National Highways Planning Response (NHPR 25-01) Formal Recommendation to an Application for Planning Permission

Council's Reference: 2025/92161

Location: Land adj, 17, Whitehall Road West, Birkenshaw, BD11 2LS

Proposal: Discharge of details reserved by conditions 4-8 (intrusive investigations), 11 (Remediation Strategy and Verification Report), 12 (CEMP), 13 (noise), 14 (Arboricultural Method Statement), 15 (CMP), 16 (highway), 17 (visibility), 18 (Safety Audit), 19 (estate streets), 20 (waste collection), 21 (surface water attenuation), 24 (bin storage), 25 (bicycle storage), 26 (drainage), 28 (drainage), 29 (CEMP: Biodiversity),-30 (landscape), 34 (solar panel array), 35 (materials), 38 (boundary treatments) on previous permission 2024/92281 for erection of 23 dwellings

Drawing No: 23/341/050/001
Job No: 23-341
Revision: L
Date: 21.02.24

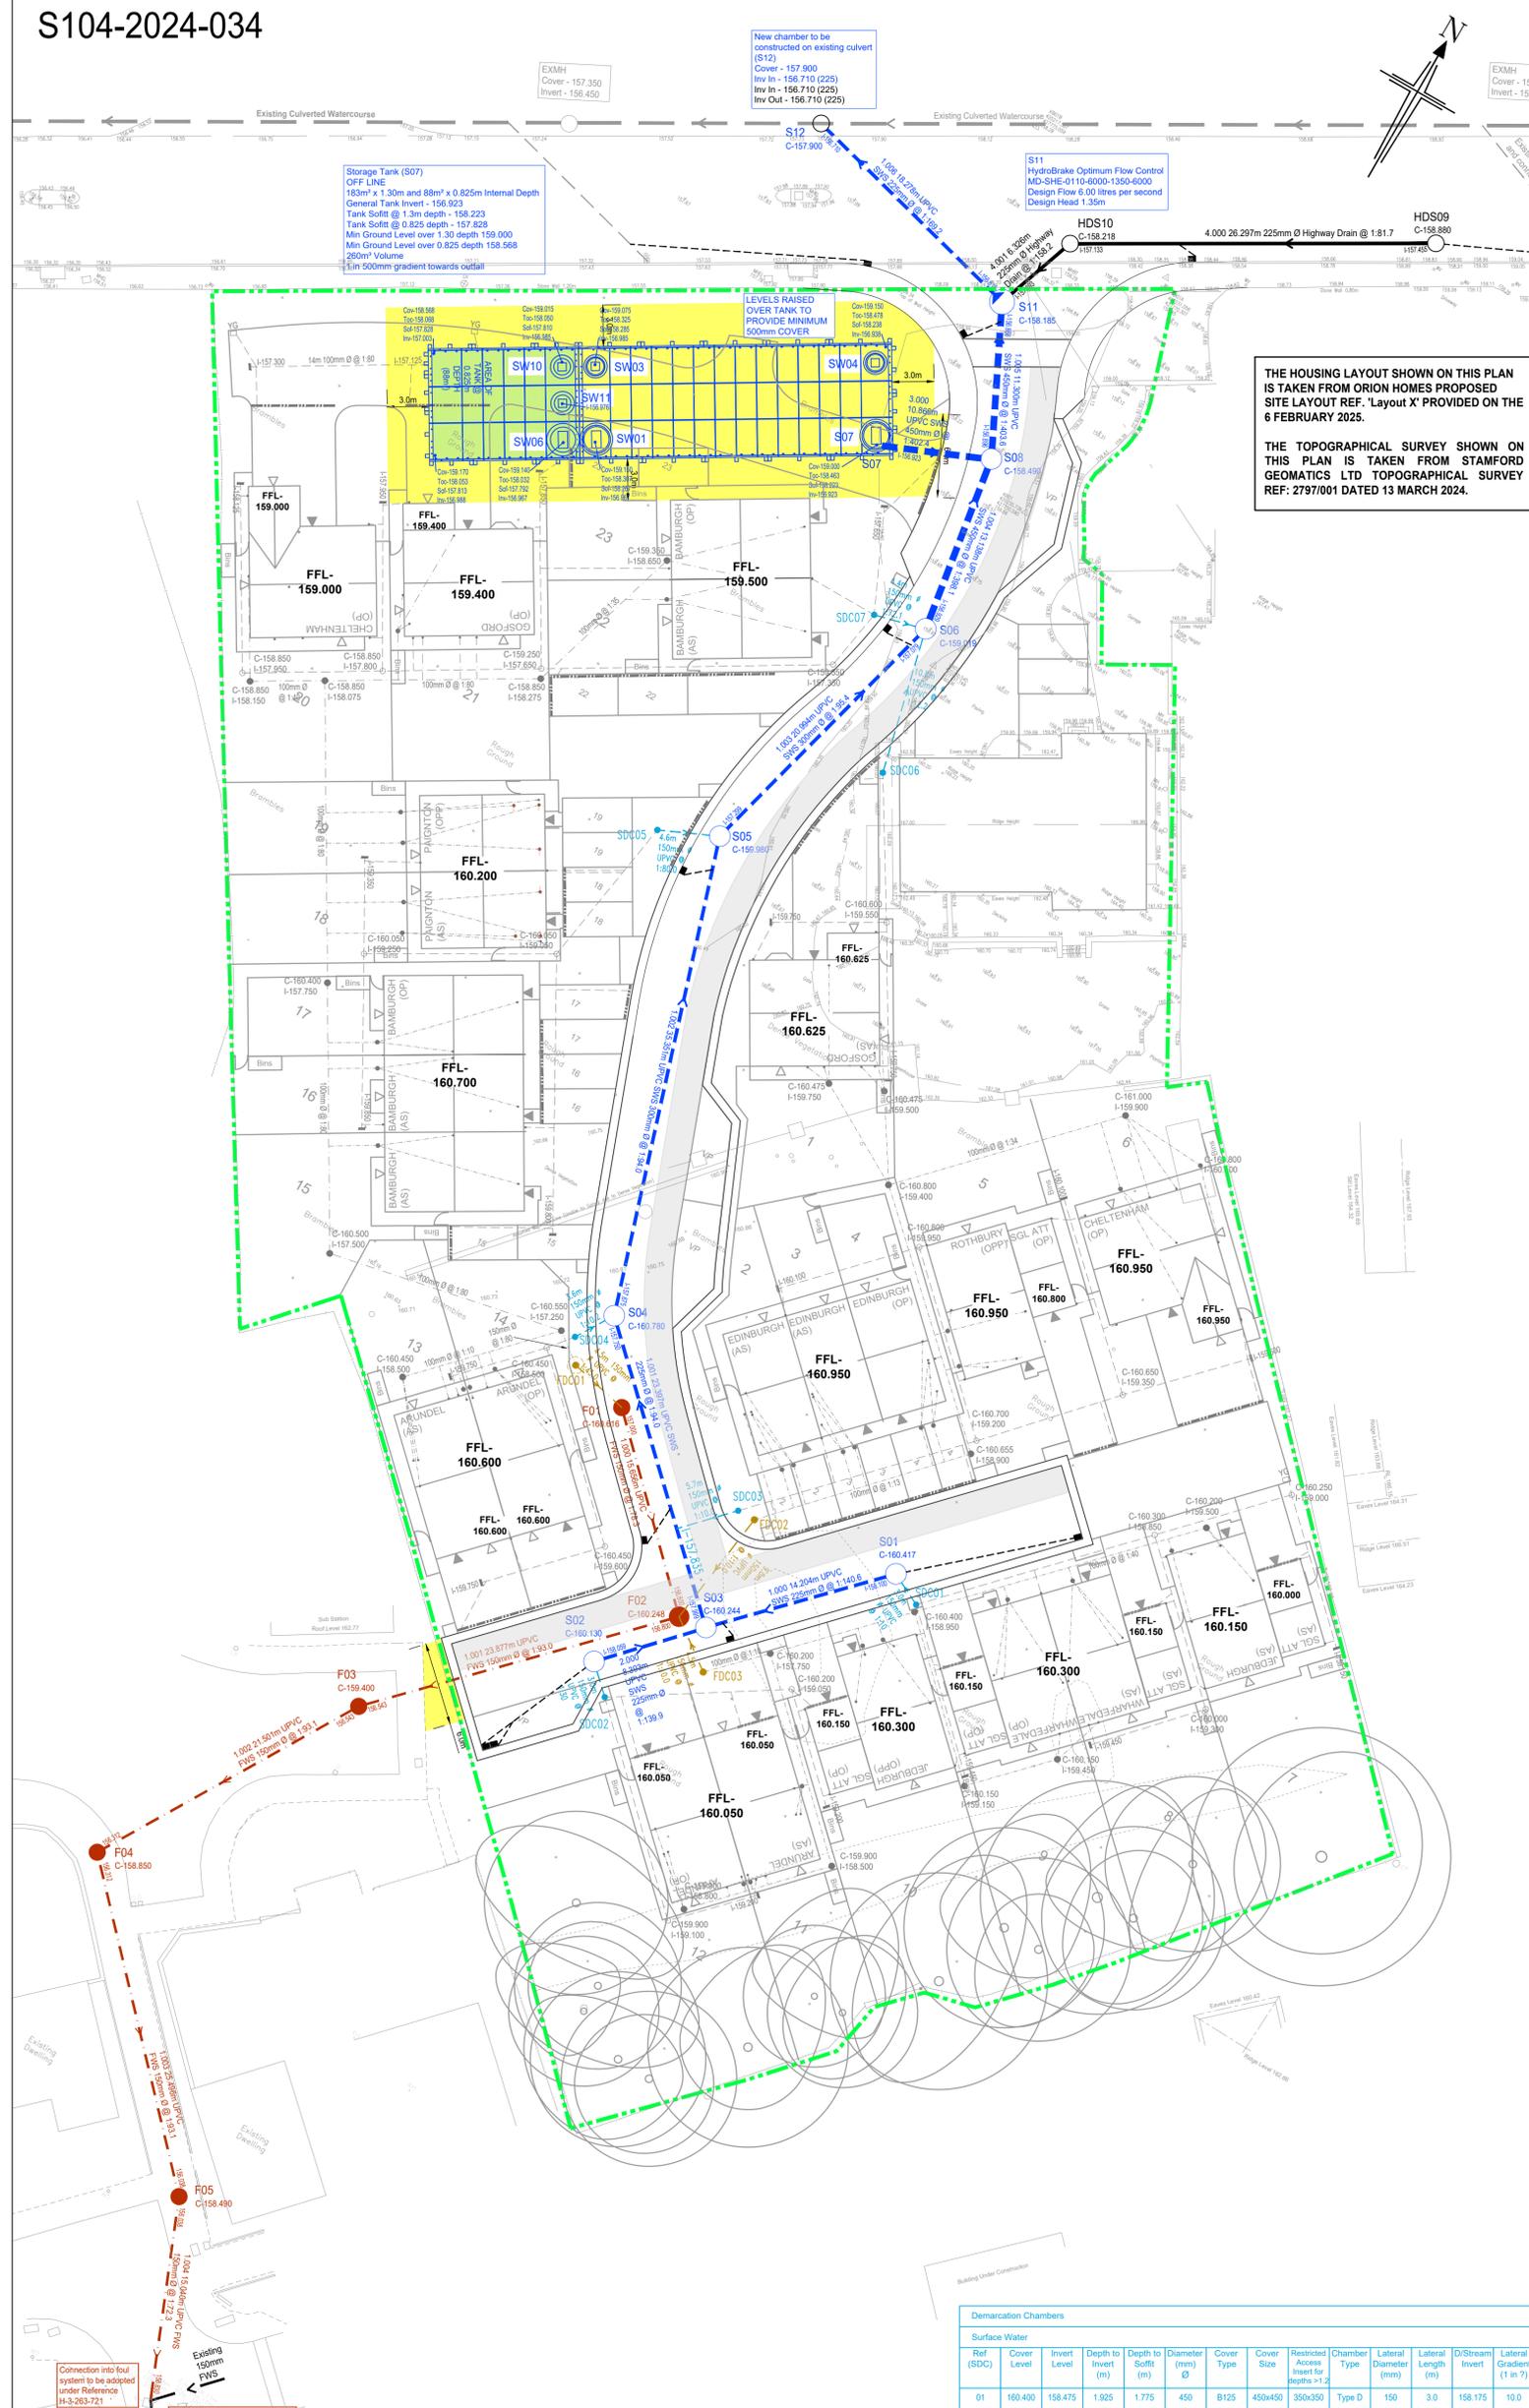
It is noted that the Applicant has submitted the following statement:

The concrete sectional tank is to be adopted by Yorkshire Water under a S106 agreement. Therefore, we do not need a maintenance and management regime in place.

However, it is unclear if Yorkshire Water are also adopting the hydro brake flow control that will restrict surface water run-off to 6l/s. As riparian owners of the downstream watercourse this particular element of the strategy is of particular interest to National Highways, and we seek surety that an appropriate management and maintenance regime will be in place. The Applicant is asked to clarify this position and provide relevant information on the management & maintenance scheme.

Title: Construction Silt / Sediment and Temporary Surface
Water Management Plan

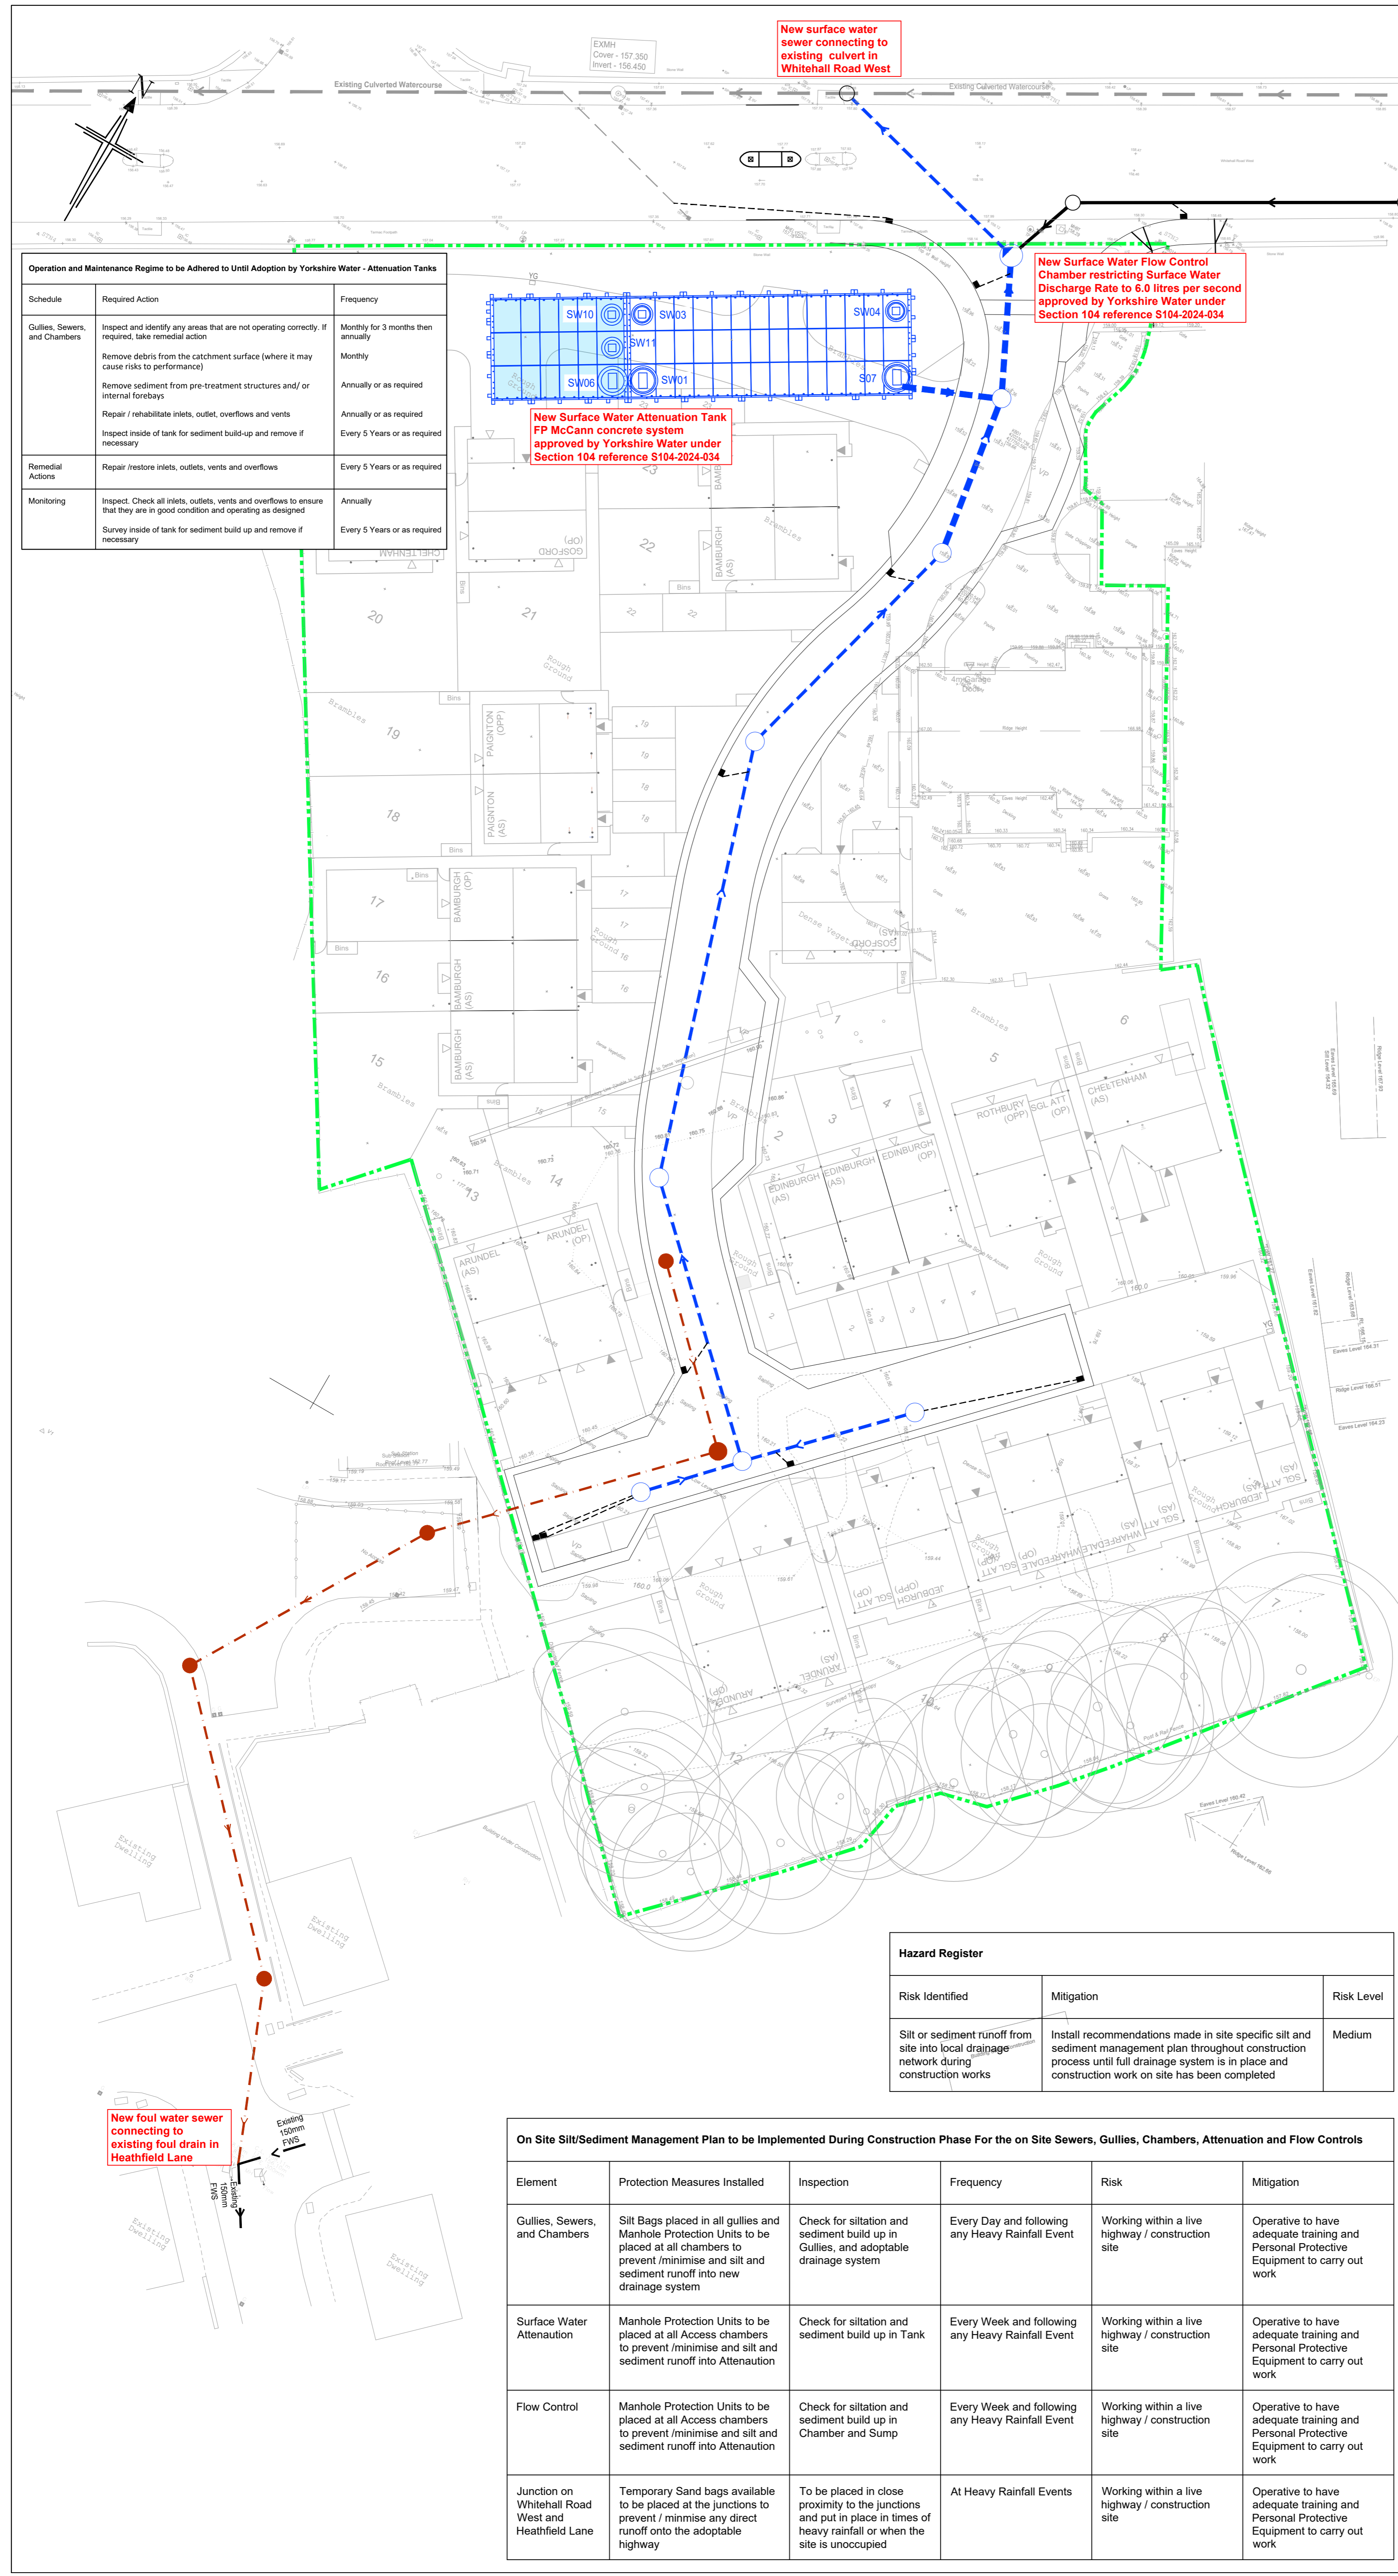
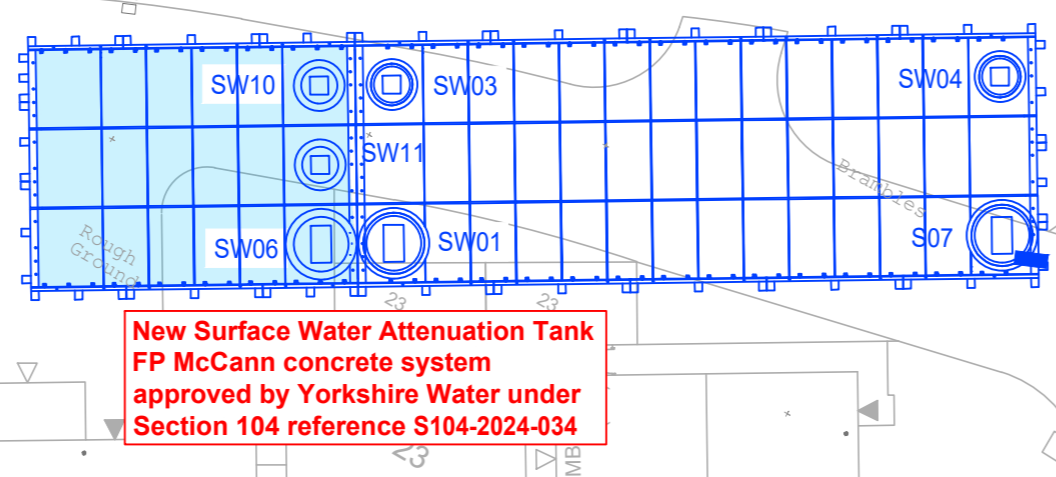
In addition, whilst it is noted that on site wheel wash facilities are to be provided there is no reference to how the site will manage the potential for debris on the public highway. Will there be a monitor and clean regime in place, and if so, how will this be deployed or will laden HGVs be sheeted? This should be made clear in the construction management plan.
